CITY OF ALBUQUERQUE

PLANNING DEPARTMENT – Development Review Services

January 27, 2015

RE: **Green Jeans Farmery - 3600 Cutler Ave NE**
Grading and Drainage Plan
Engineer's Stamp Date 12-19-2014 (File: H17D036A)

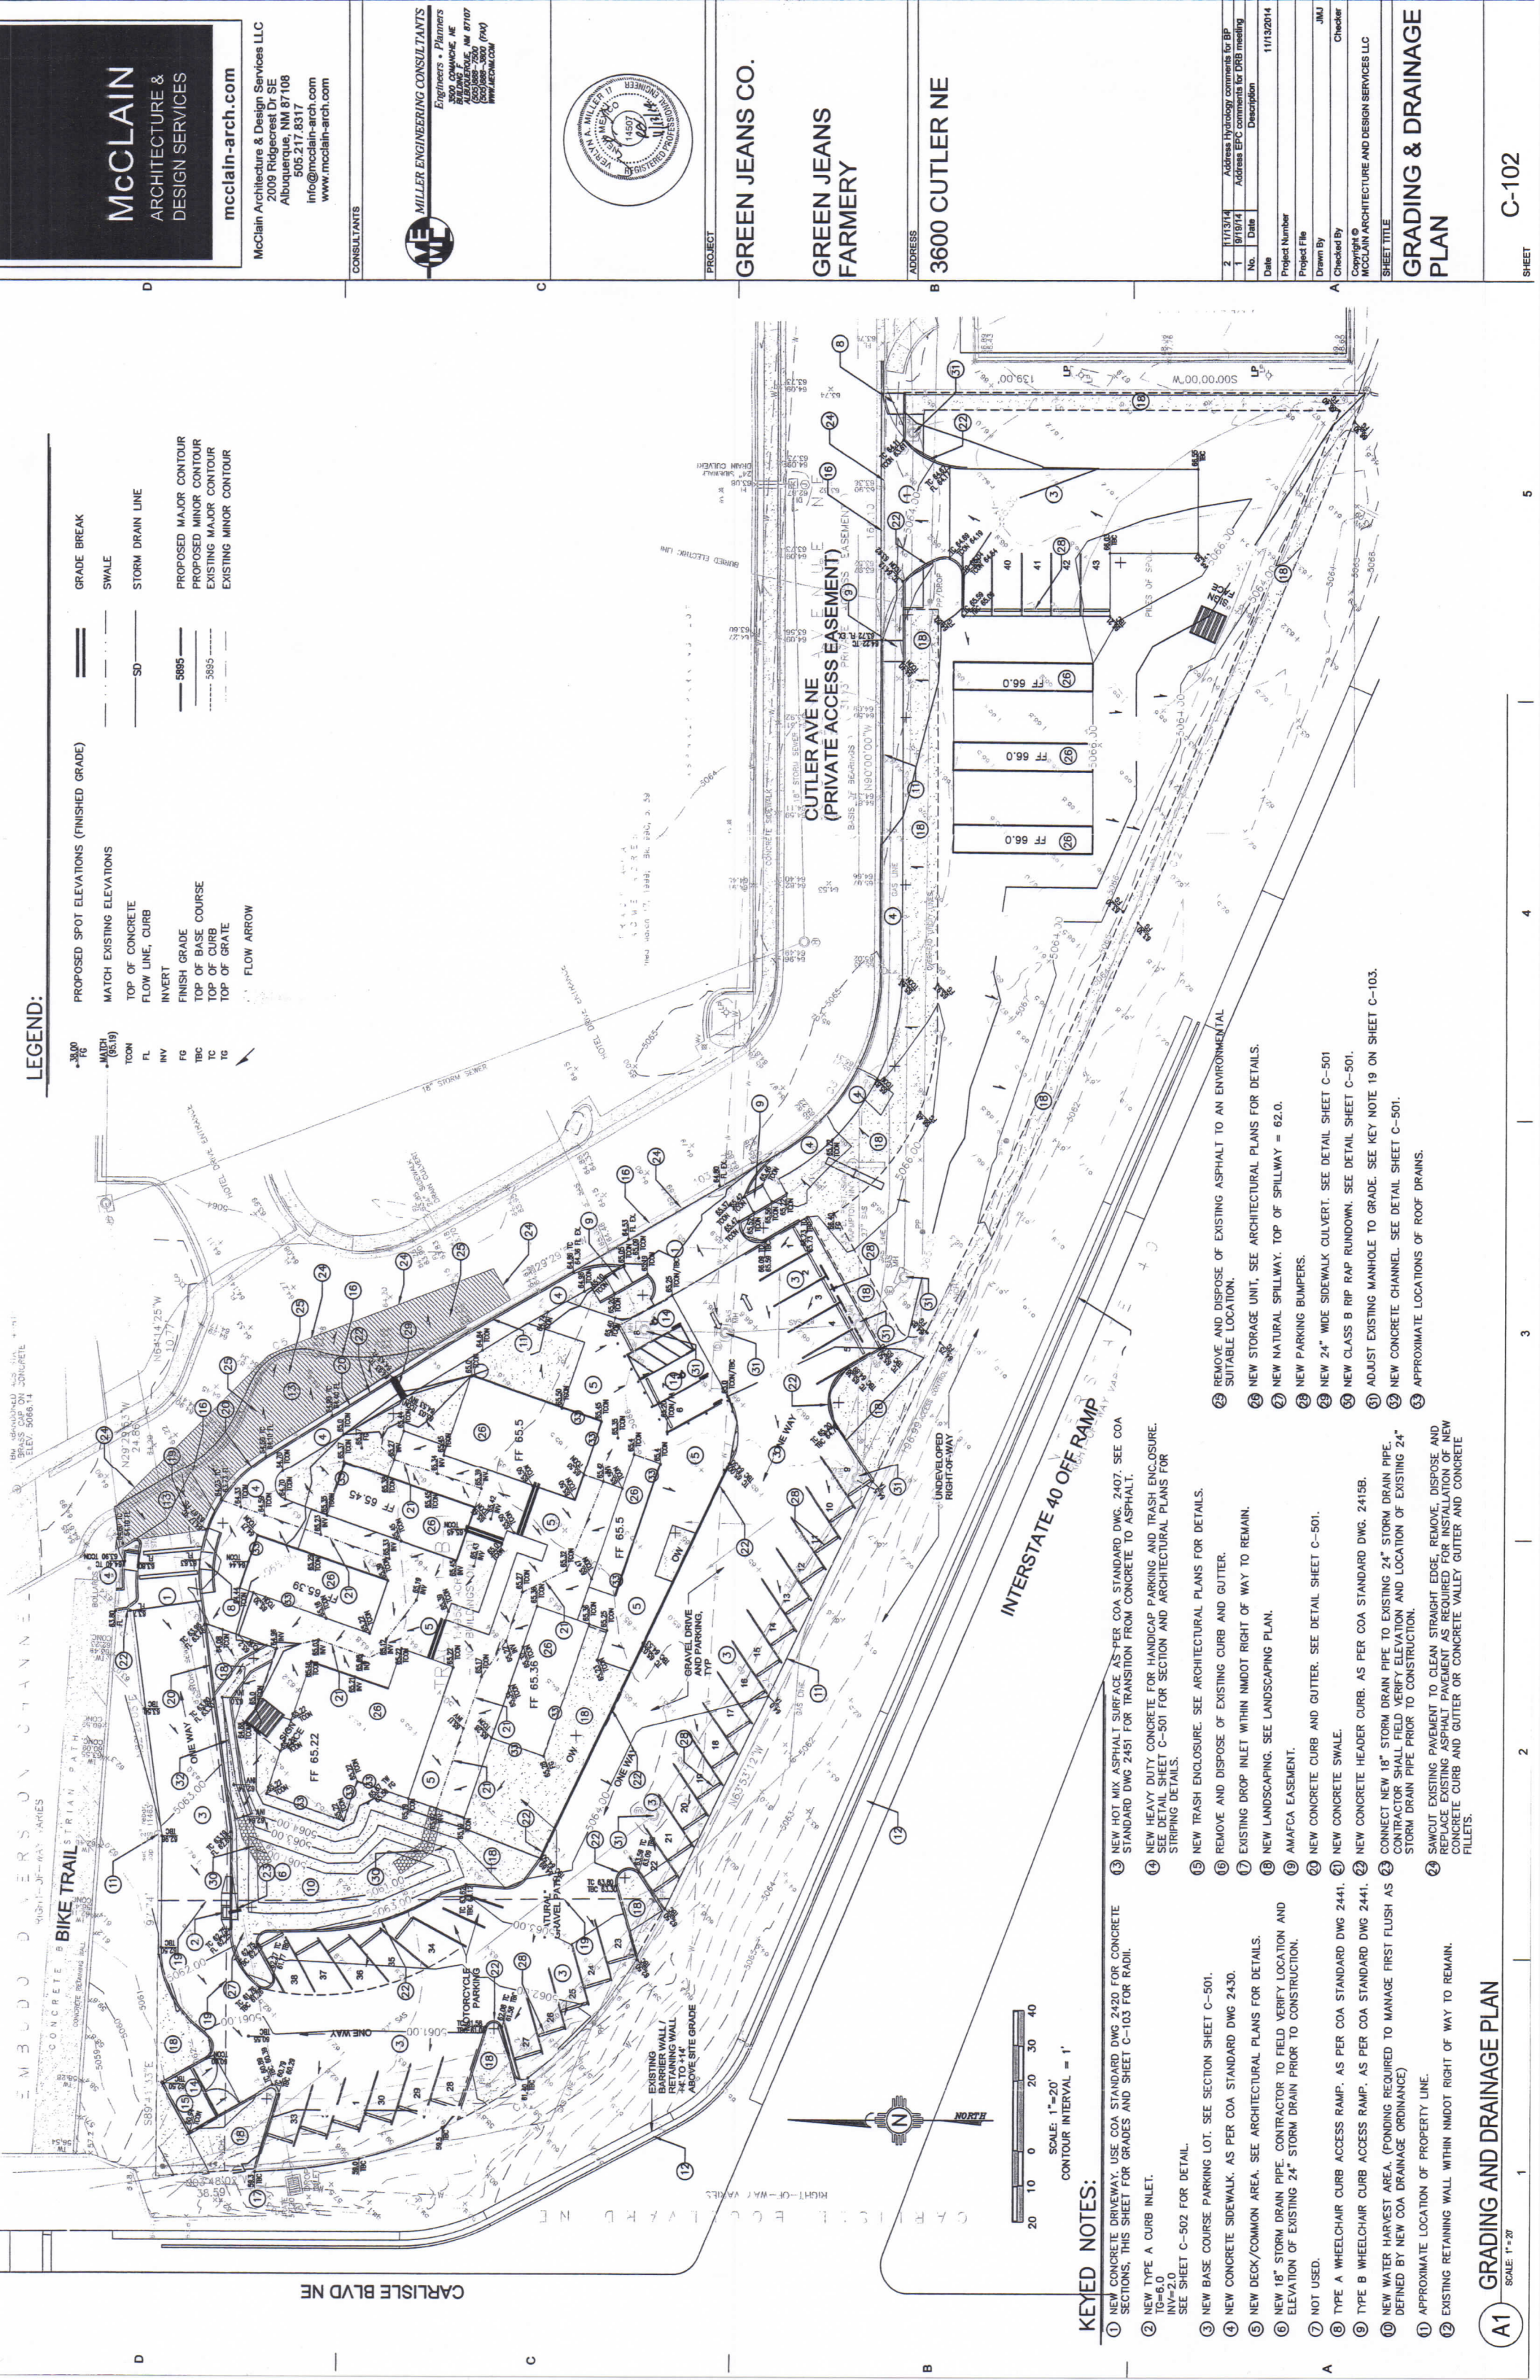
3. Amend the narrative and the Conclusion on the Drainage Report to state that the peak discharge is 5.22 cfs.
4. Along the South edge of site, along the NMDOT ROW/easement, there need to either be a retaining wall or match existing grades at the property line.

5. NMDOT approval is required since there is an increase in runoff from 4.9 to 5.2cfs to a NMDOT facility, and grading adjacent to their facility.
6. Roof discharge from containers labeled Tenant 3, 4, 5, and 6 (or the east most collection of containers) should be directed towards the first flush pond.

7. Turn off traffic pattern layer – much too cluttered.
8. Contour labels are to faint to read.
9. ~~AMAFCA permits need to be obtained. Contact Lynn Mazur.~~ O/K
